### **Comment: Failure to Properly Assess the Relationship Between Plot 23 and No.92 Lingards Road**

I object to the current application on the basis that the relationship between Plot 23 and No.92 Lingards Road has still not been properly assessed.

The current application is 2026/91657, and KC is again the case officer. This application was submitted before I asked for No.92 to be properly assessed. After that request, KC sought access to to take photographs. That had not been requested or undertaken during either of the previous applications. It therefore appears to be a direct response to my request for a proper assessment of No.92.

Rev B	03/06/2026	Updated for planning submission.		
Rev A	24/09/2025	Minor amendments, dimensions added.		
Project :		Housing at Lingards Road, Slaithwaite.		
Client :		SB Homes.		
Drawing :		Plot 23 - OPTION 1.		
Scale :		1:100.	Date :	May 2025
Dwg No :		2019 572 Sk 15	Rev :	B

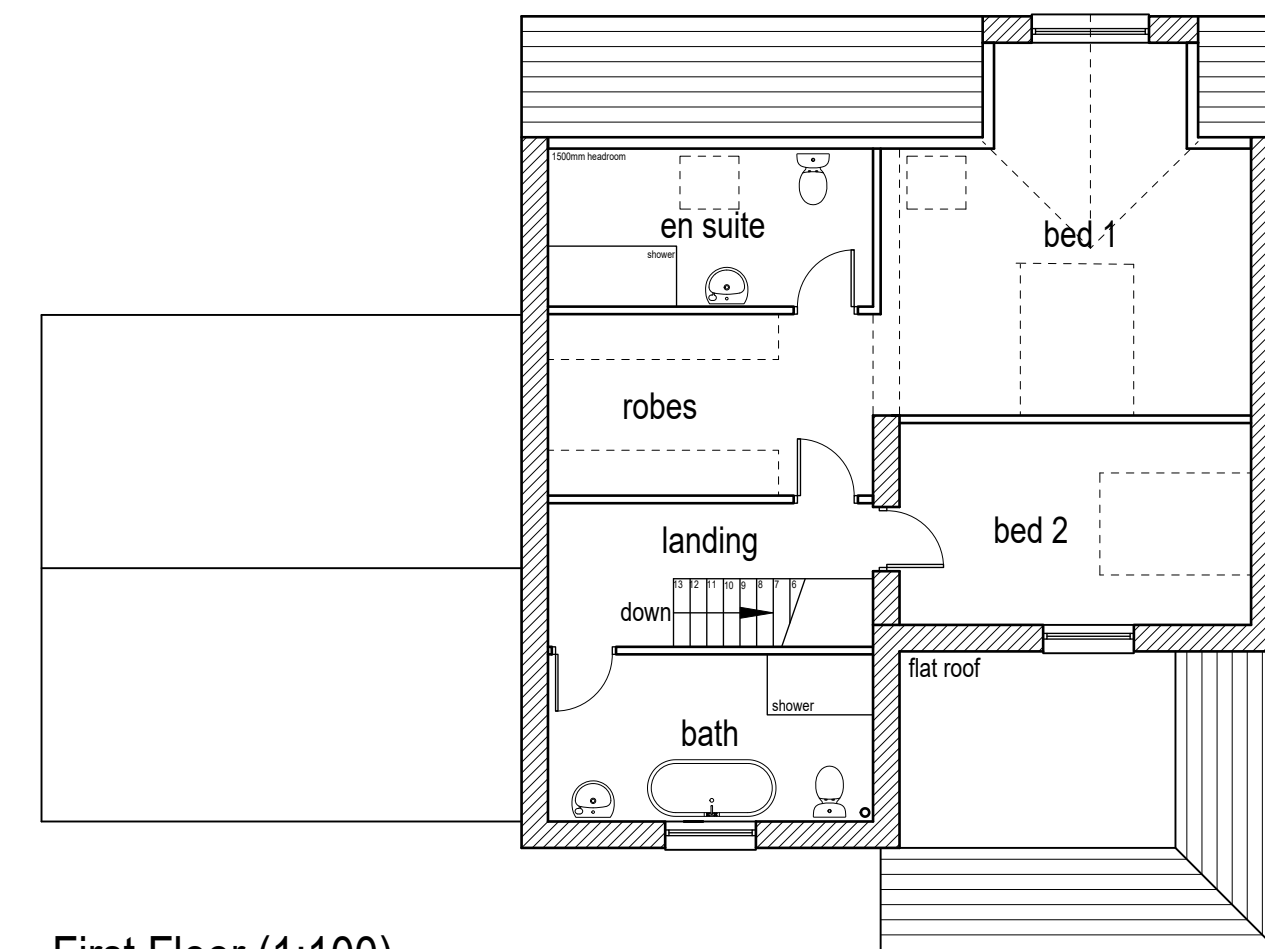
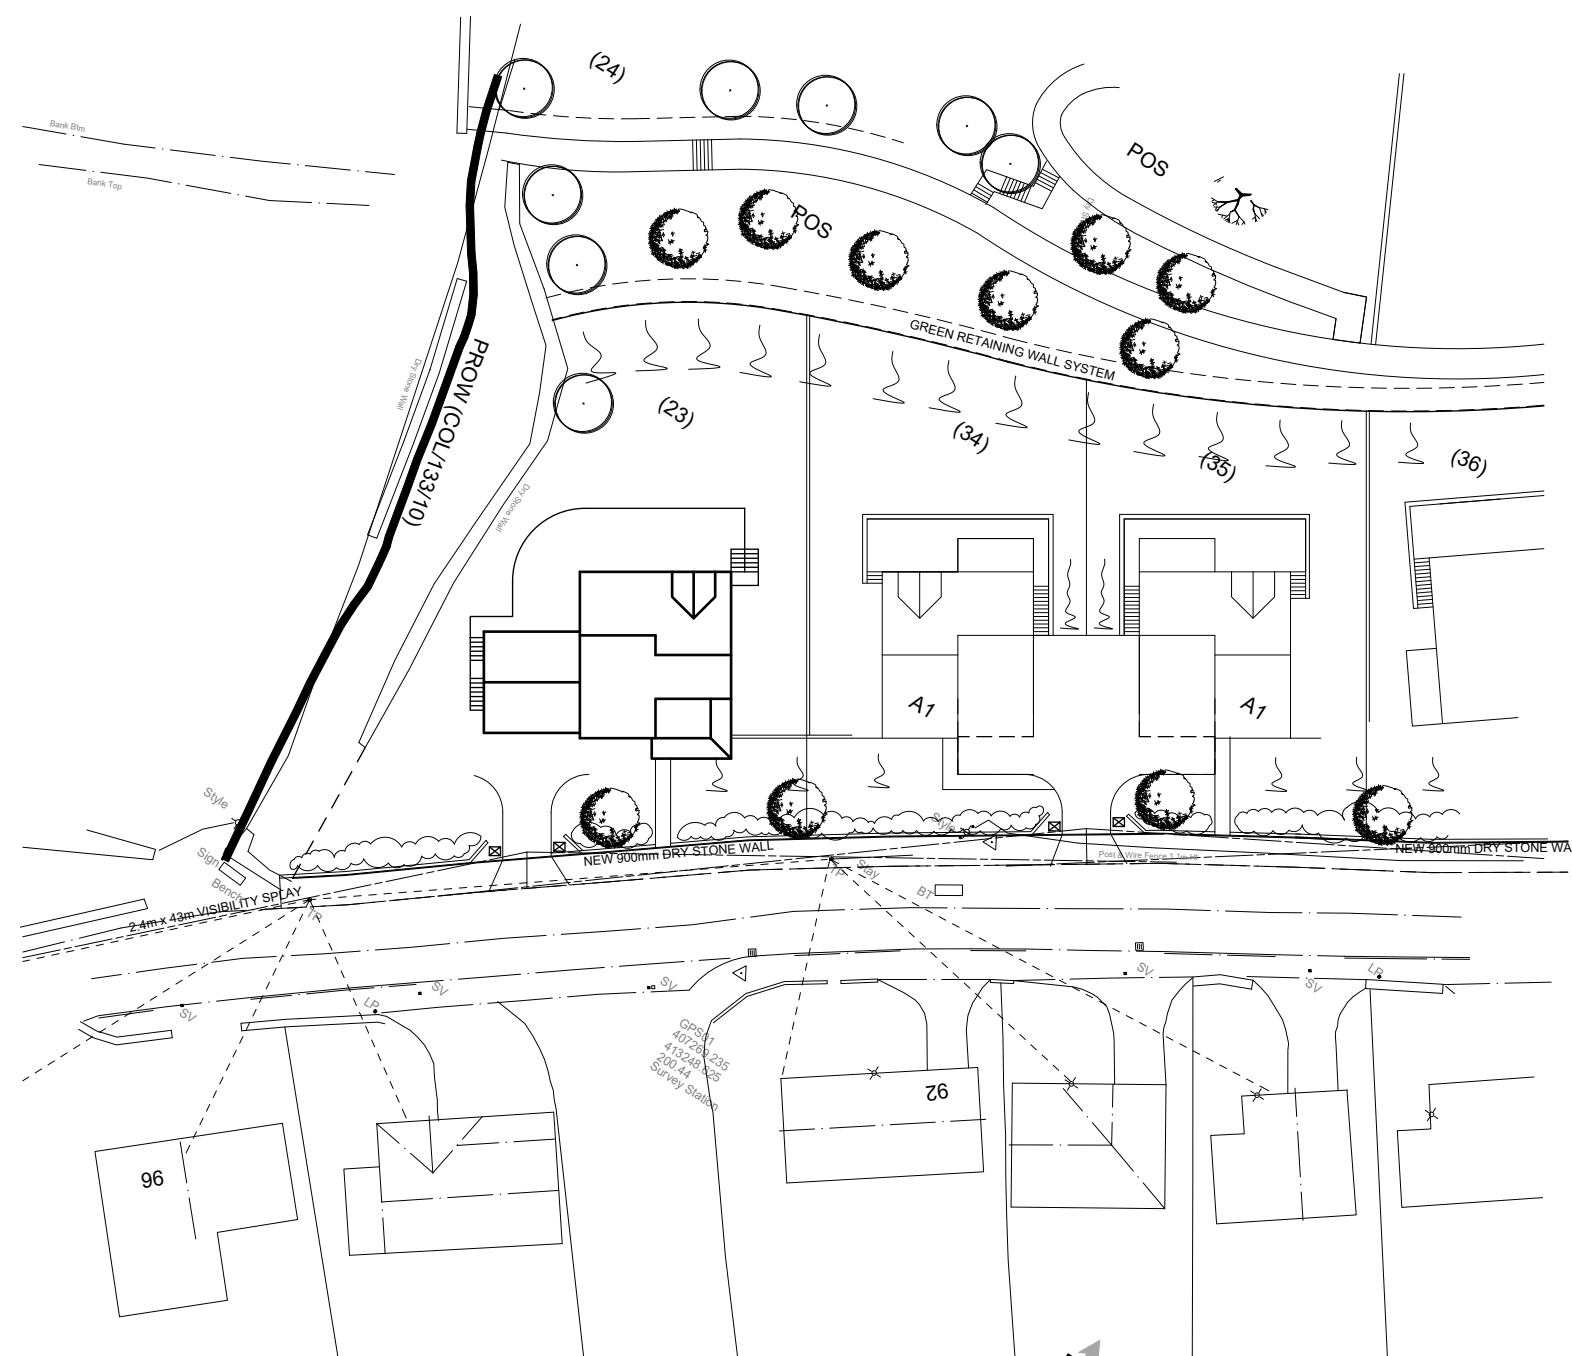
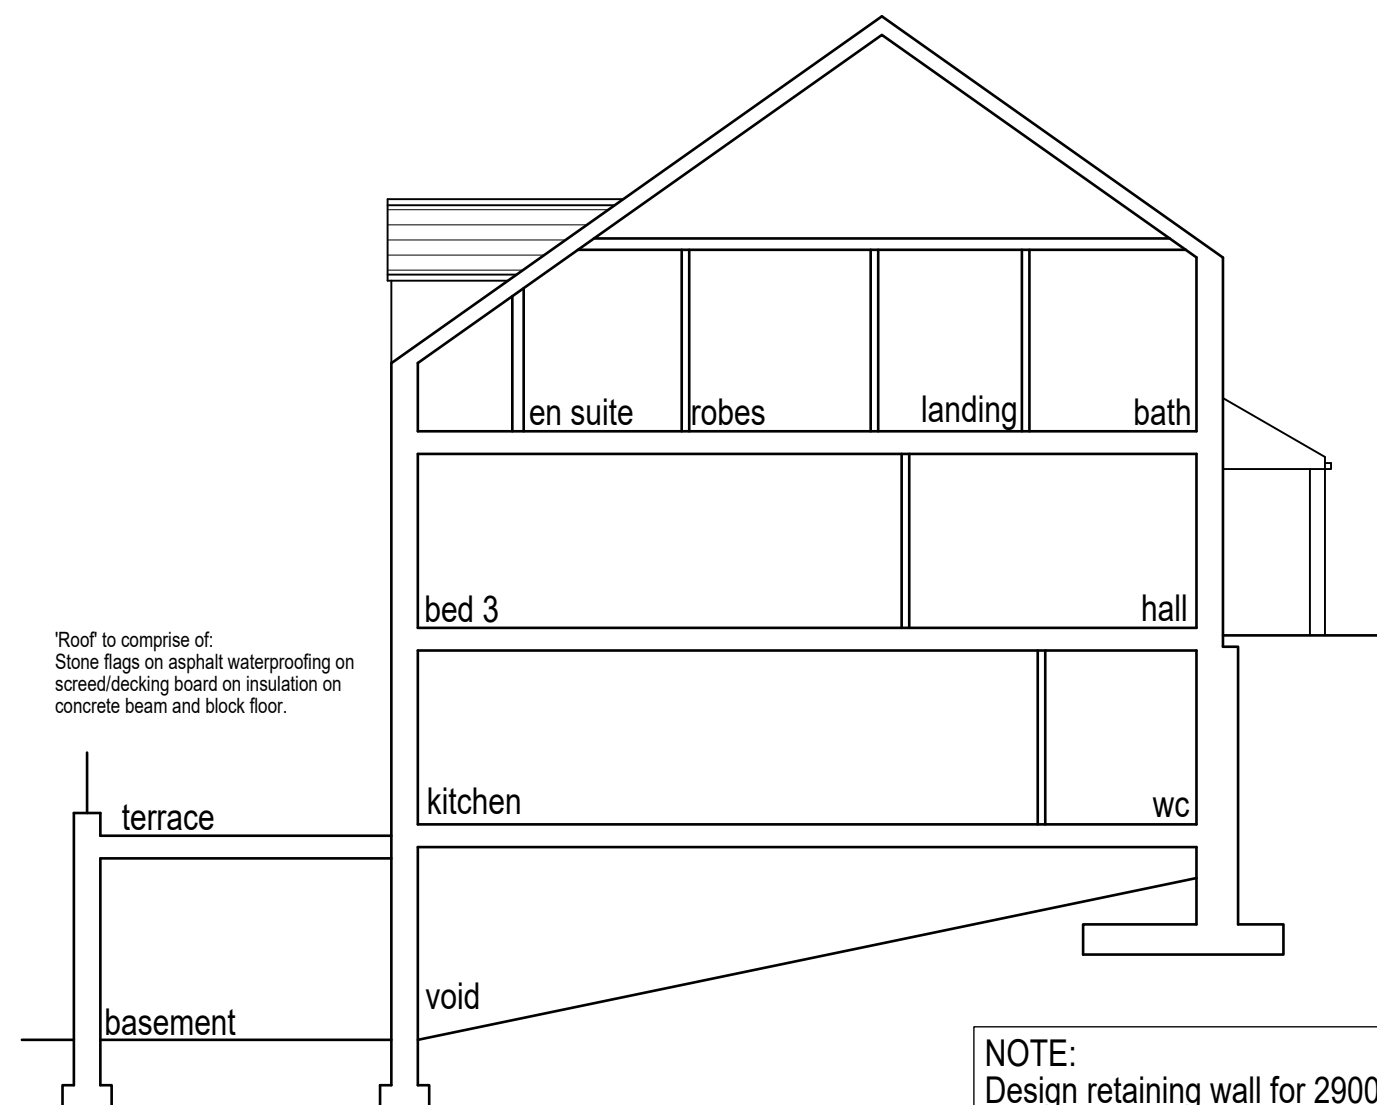
My simple position is this: a house of height X, starting from elevation Y, will necessarily be higher if it starts above elevation Y. If the ground-floor level is higher than approved, the ridge, windows, roof form and overall massing will also be higher unless the building is reduced elsewhere. It should not be necessary to wait until the house is complete up to ridge level before deciding whether the approved levels have been exceeded. The approved drawings and the as-built ground-floor levels should allow that calculation to be made now.

The cumulative position is now far more serious than the earlier double-garage concern alone. The current proposal involves a doubling of the garage, an enlarged kitchen area beneath it, greater width, greater height, increased elevation, additional habitable or usable levels, a raised terrace, a garden room/store beneath that terrace, and unresolved concerns about the siting of Plot 23.

For these reasons, I ask the Council to assess 2026/91657 afresh, using the actual built position, actual levels, actual relationship with No.92, the lawful side extension at No.92, and the cumulative effect of the double garage, increased massing, raised terrace, lower-level garden room/store, increased height and siting concerns.

Roof plan (1:200)

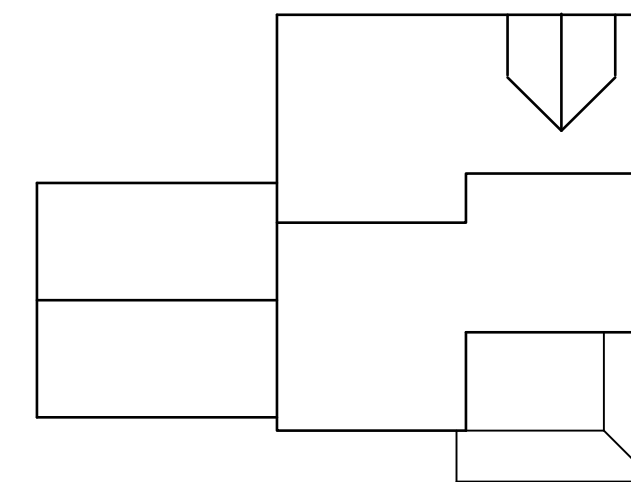
Part of my concern also relates to the elevation of Plot 23. I had measured that Plot 23 appeared to be higher than it should be. In response, JS said that because Plot 23 was unfinished, the Council could not yet accurately assess the overall height or the relationship with No.92.
